## MEMORANDUM

**TO:** Nell Donaldson, Planner  
**FROM:** David Senus, P.E.  
**DATE:** May 3, 2013  
**RE:** Pomeroy Street Construction, Level II Site Plan Application

Woodard & Curran has reviewed the Response to Comments letter and attachments for the Level II Final Site Plan Application for the Pomeroy Street extension located off of Bancroft Street in Portland, Maine. The parcel was previously approved for a Site Plan and Conditional Use Permit in August of 2005 by the City for a single family residence with attached synagogue; however, these permits have since expired. The current amended project consists of developing a single family home (Level I) and construction of approximately 200 linear feet of Pomeroy Street (Level II).

**ROADWAY SECTION**

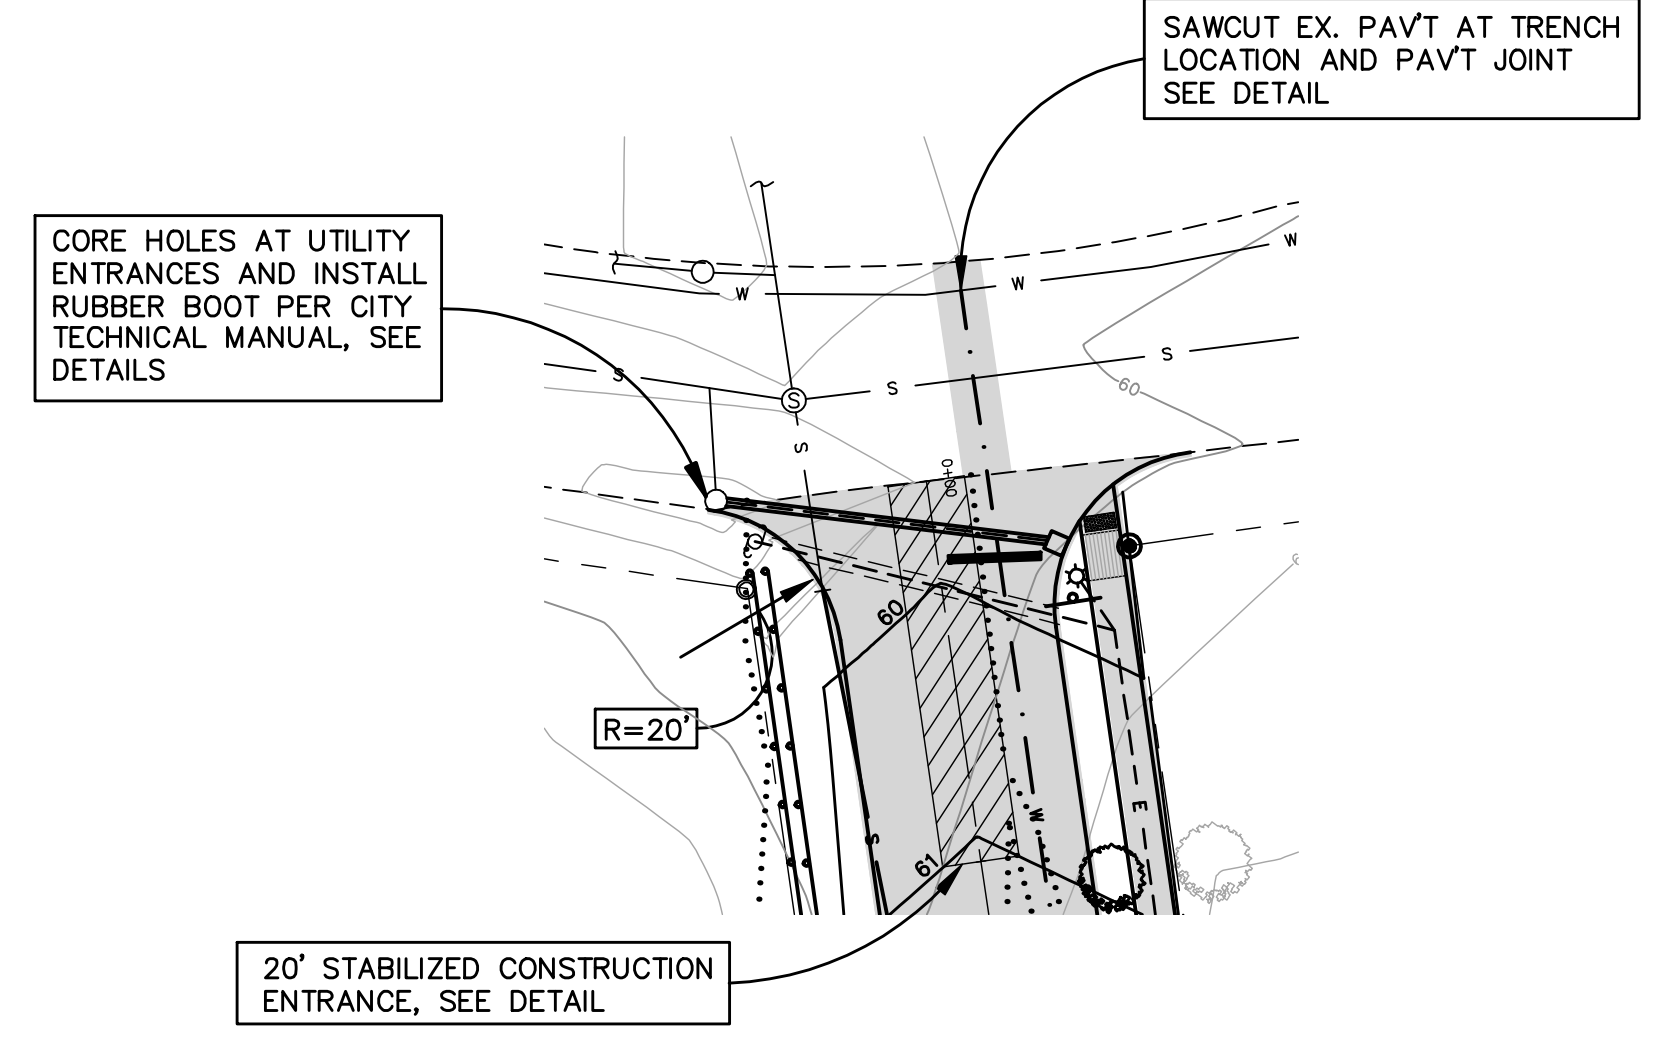
- 6) As designed, the roadway cross slope transitions to the curtain drain inslope (3:1) along the eastern edge of the road with no shoulder to back the pavement. The design should include at minimum a 12” shoulder to back the pavement edge. The loam & seed inslope to the curtain drain should either be sodded or should include a temporary erosion control matting to prevent erosion of the loam into the curtain drain.

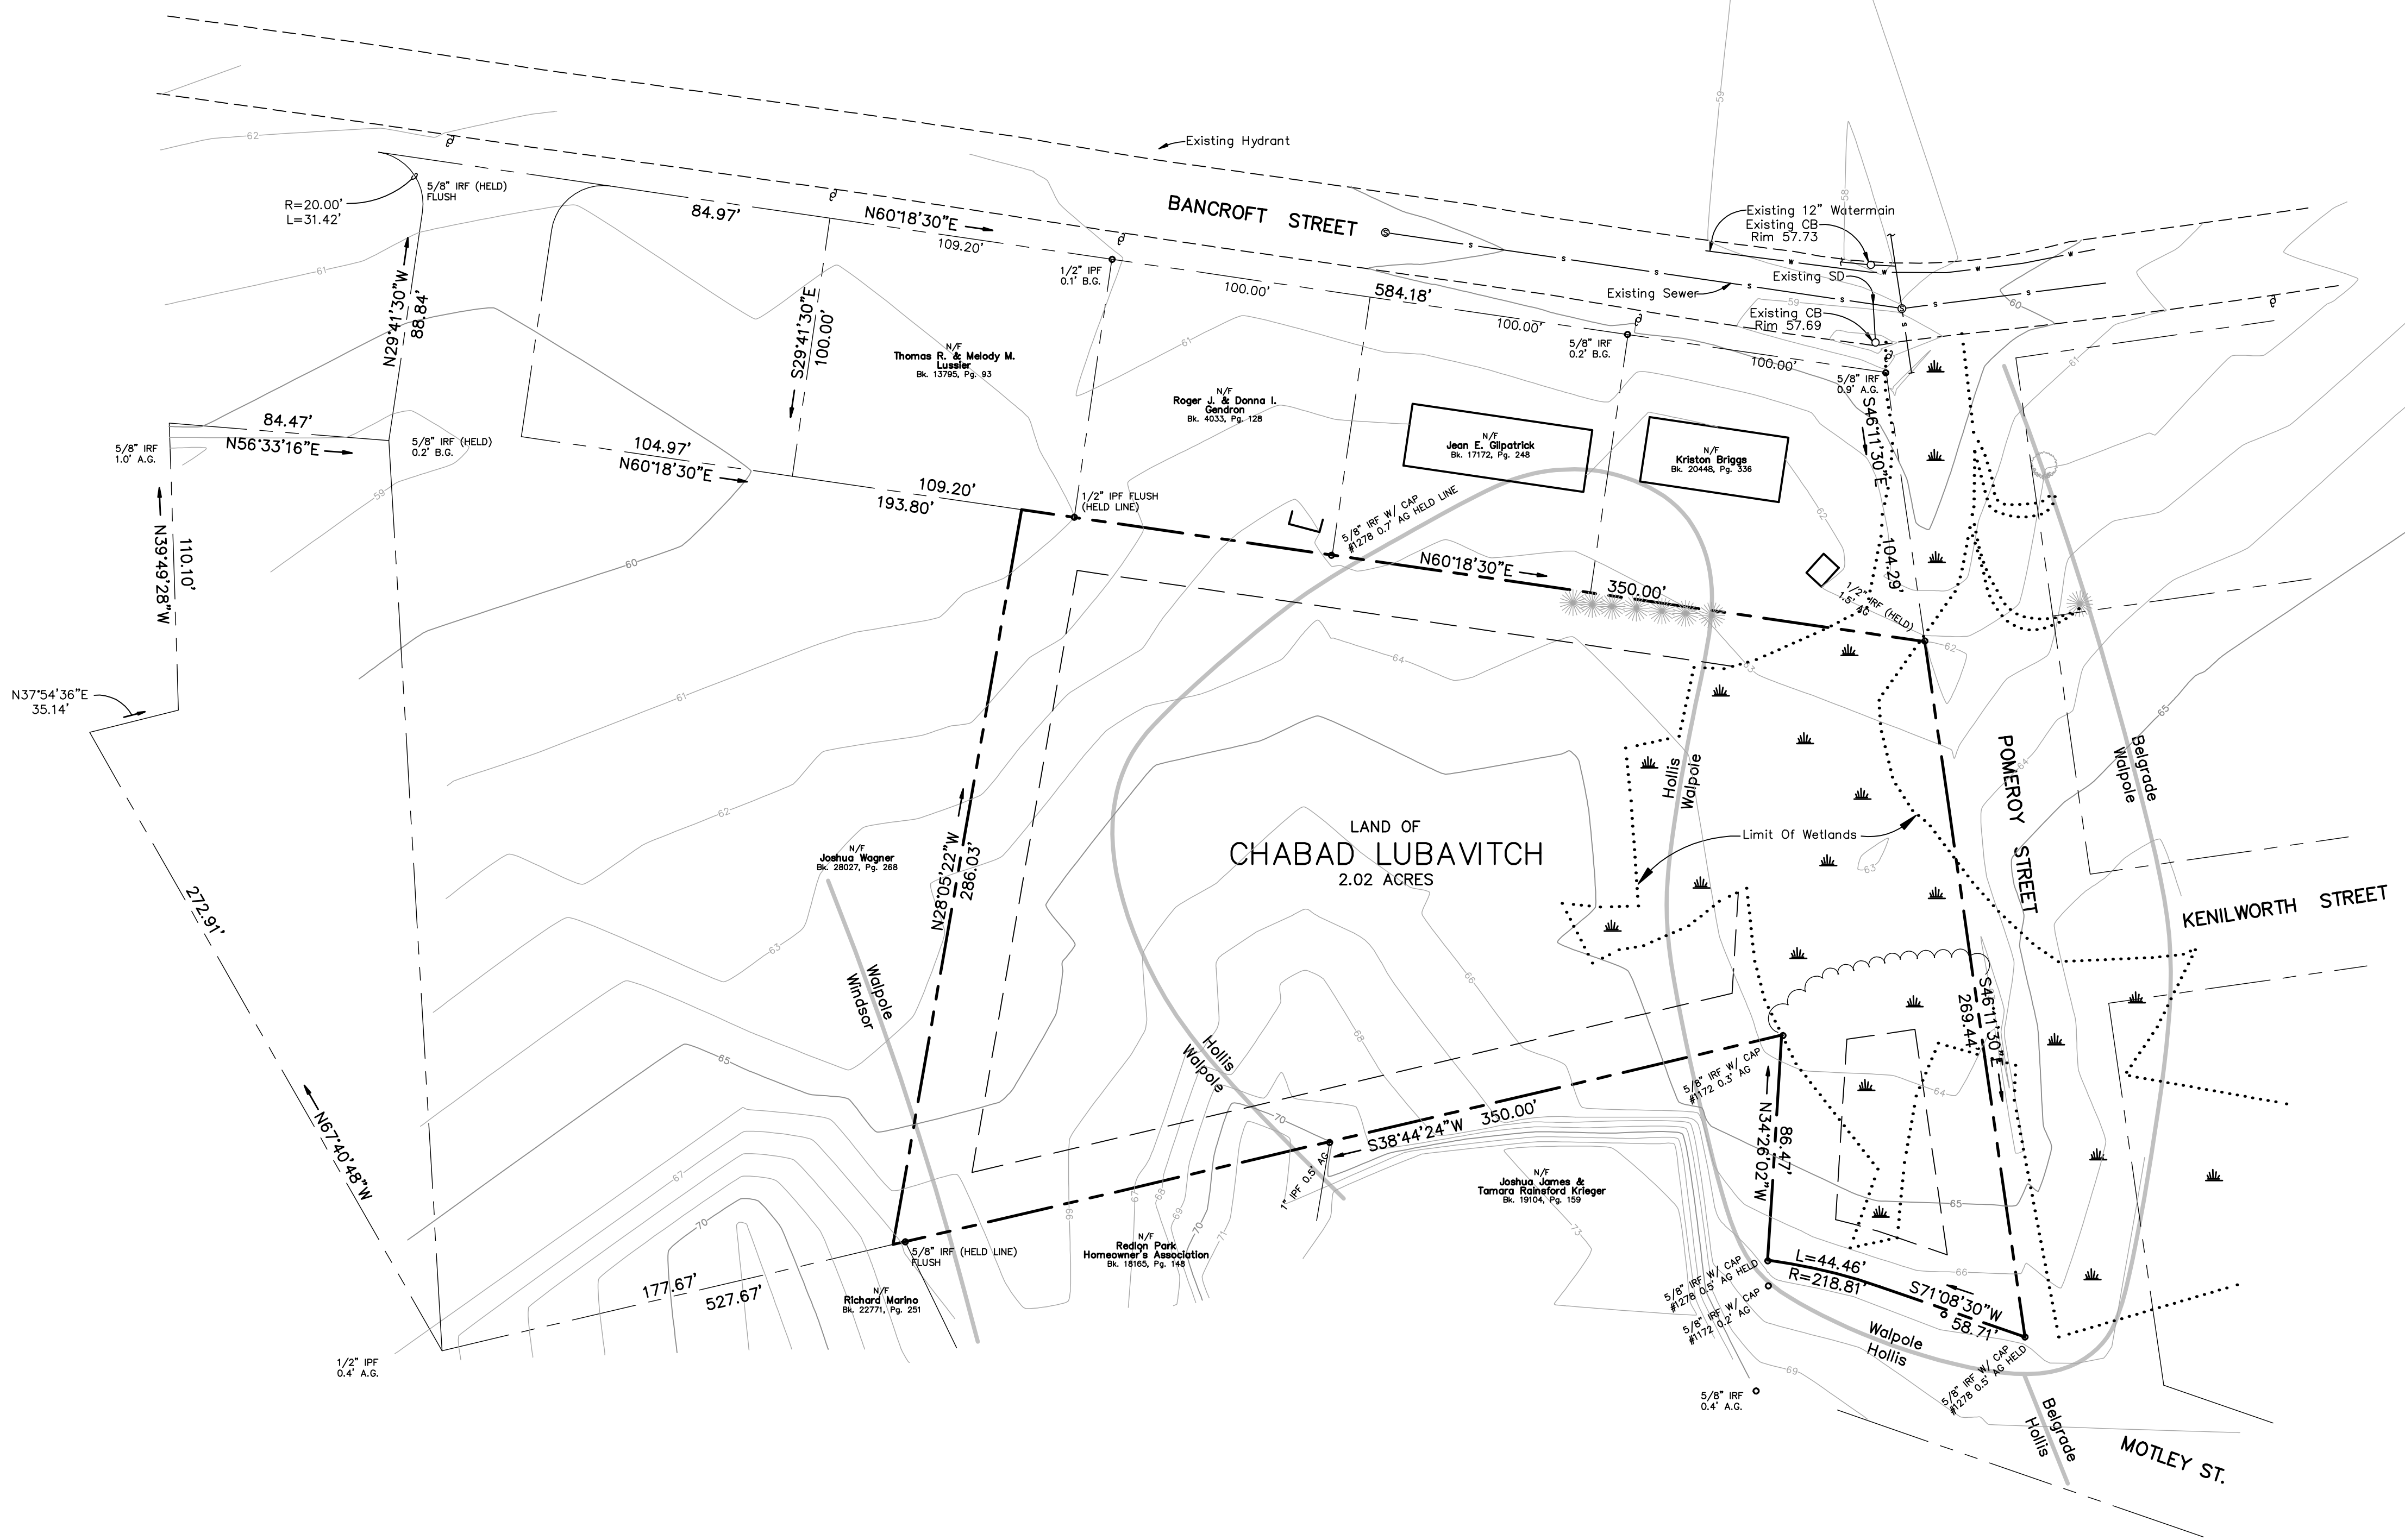
- 5) The design of the entrance driveway and associated driveway inslope will direct runoff from the single family residential lot and other upland areas (conveyed through a culvert below the driveway) across the Briggs property. The site plan should be modified to prevent an alteration of flow onto the neighboring property, and provide a means of conveyance on the Applicant’s property and within the proposed Pomeroy Street Right-of-Way.
